Subject: RE: 8 Fernhurst gardens.

Kathryn Welch
Planning Officer, Planning Department

Drawing no.003
Date 27/09/20
Issue 02 NTS
Dimensions added

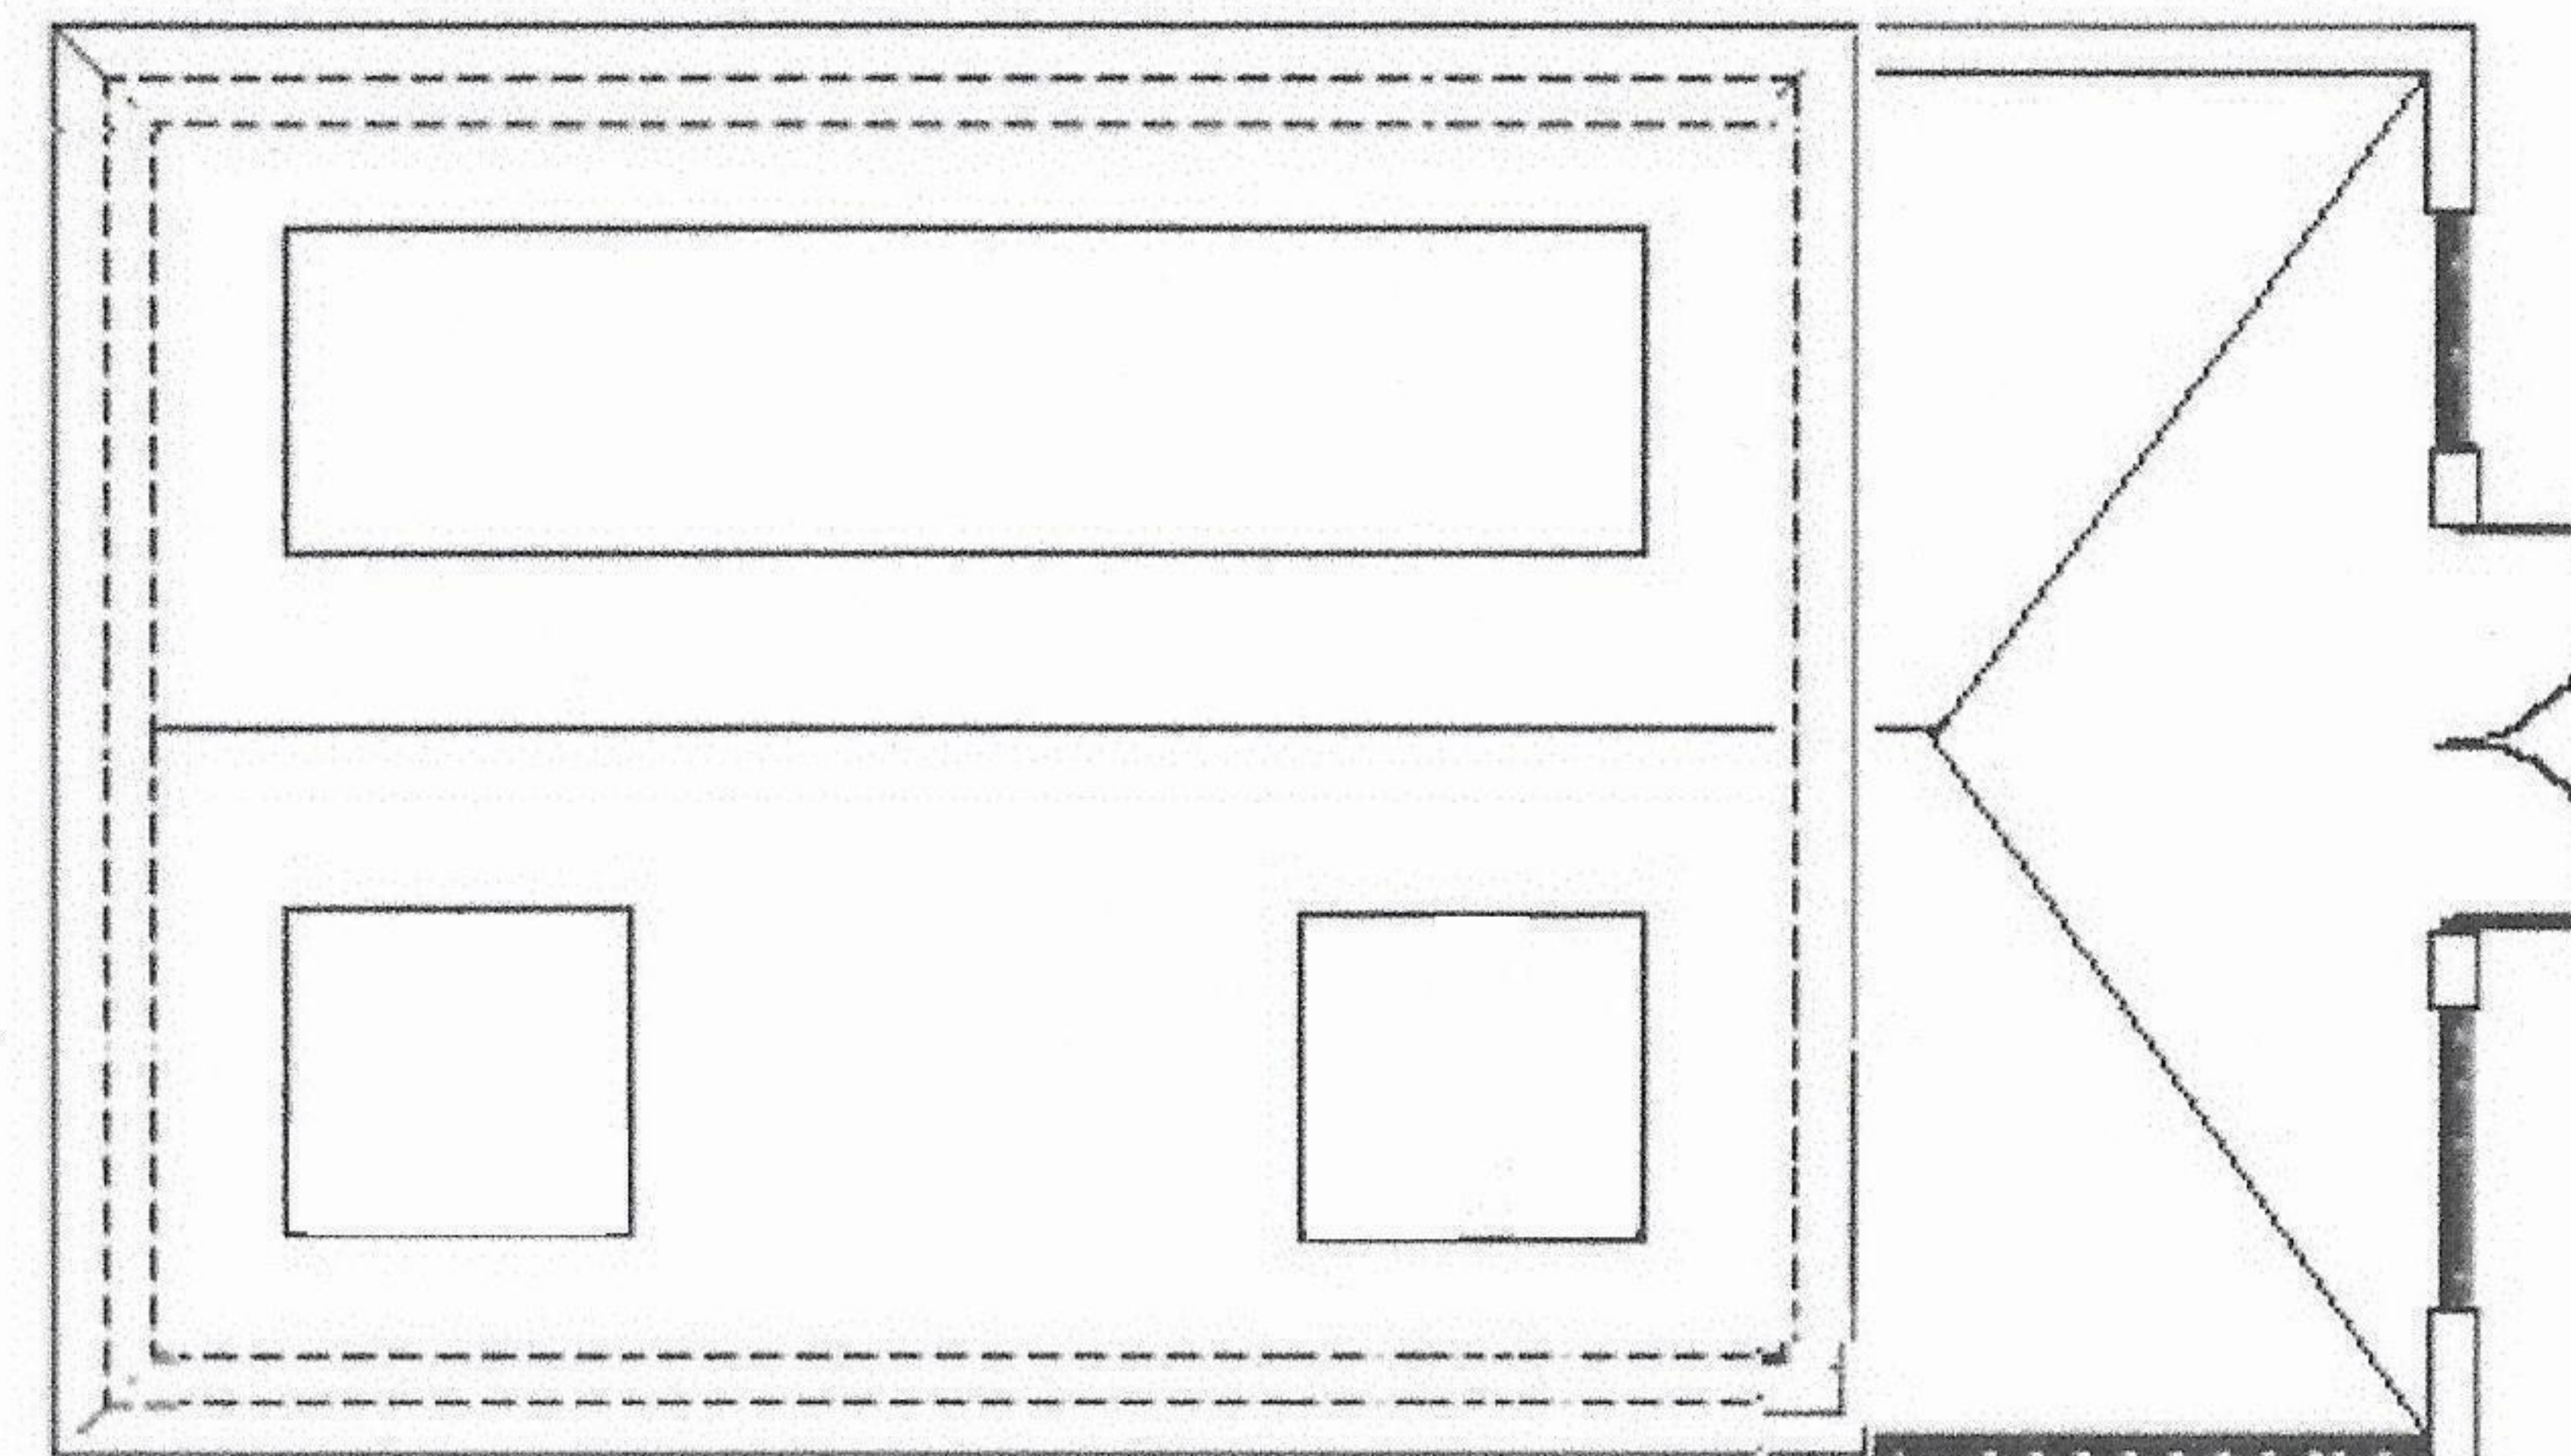
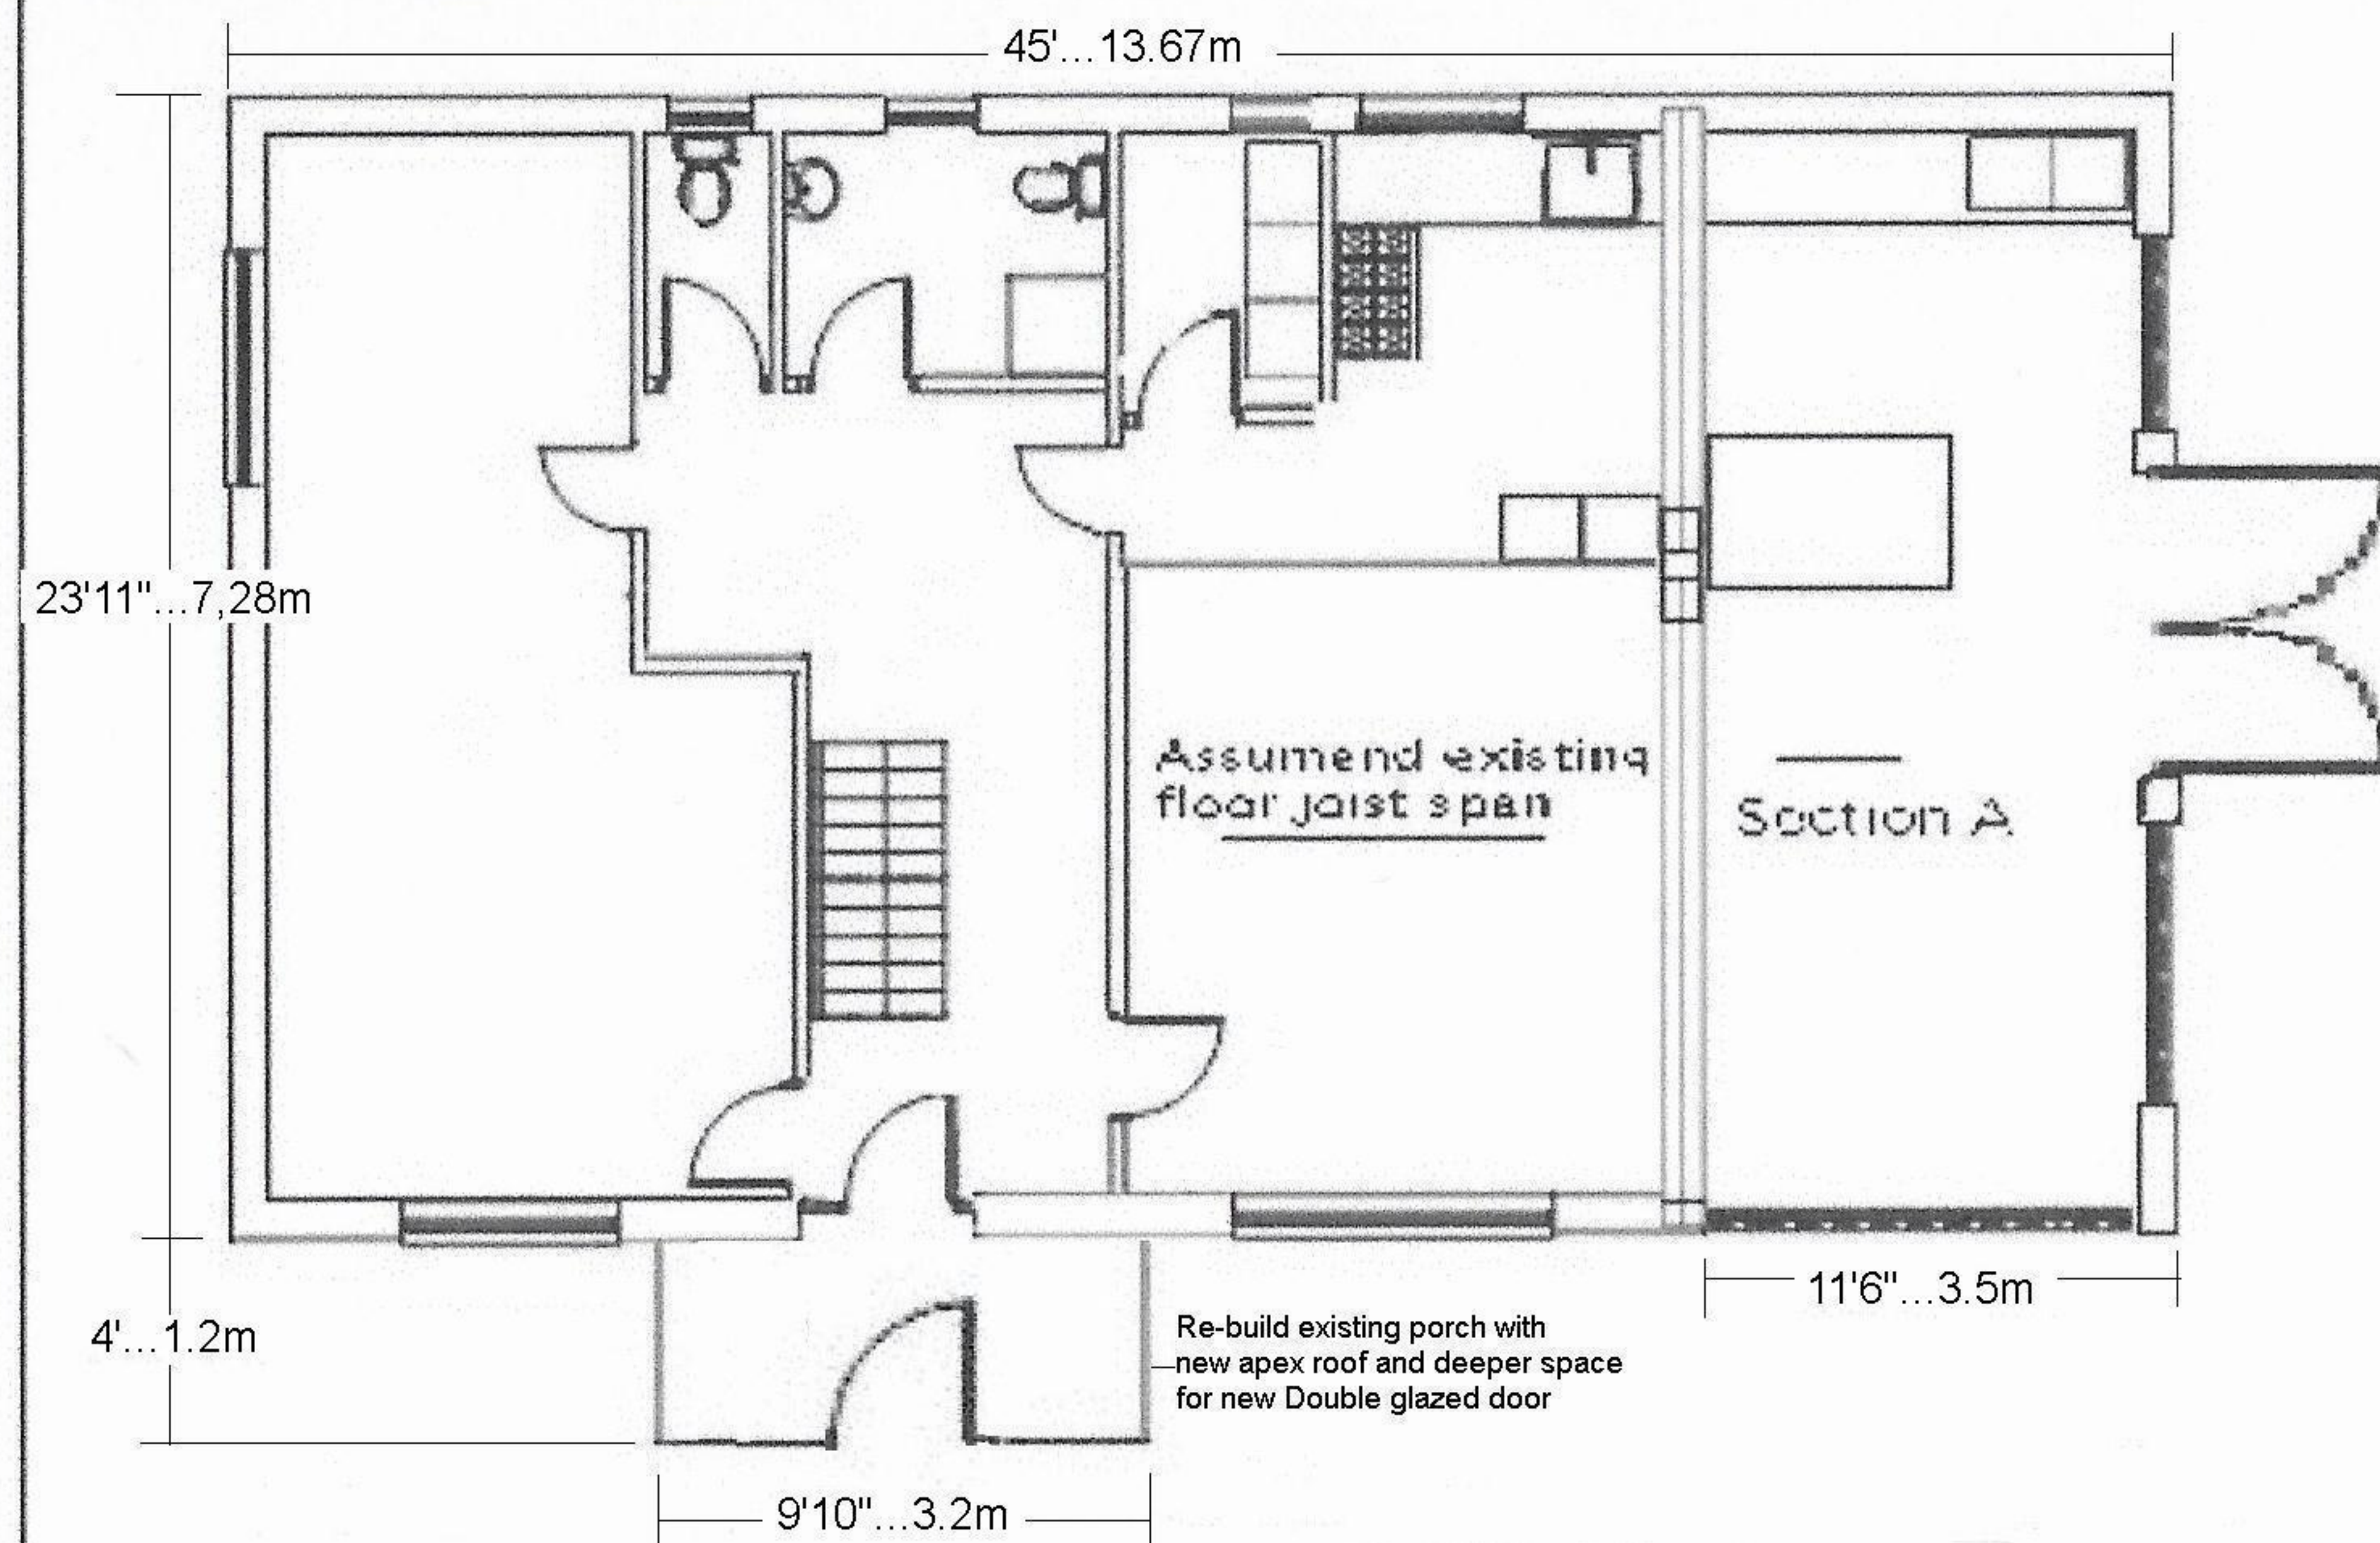
- The porch is slightly too large, to be covered by PD rights the maximum allowance is 3m² and your proposal currently measures at 3.84m² can you adjust this on plans 010 and 003.
- Can I have confirmation of the height to the eaves for the extension, either via email or included within a plan,
- Can you confirm that the extensions will be built of materials to match the existing property. You've noted a concrete slate tile on the roof of the extension; do you already have these on the existing house or can you amend to something similar to the existing,
- Can you confirm the proposed hardstanding for 2-3 cars will be built of either porous materials or will drain off to water permeable area within the site, again just a written confirmation will suffice.
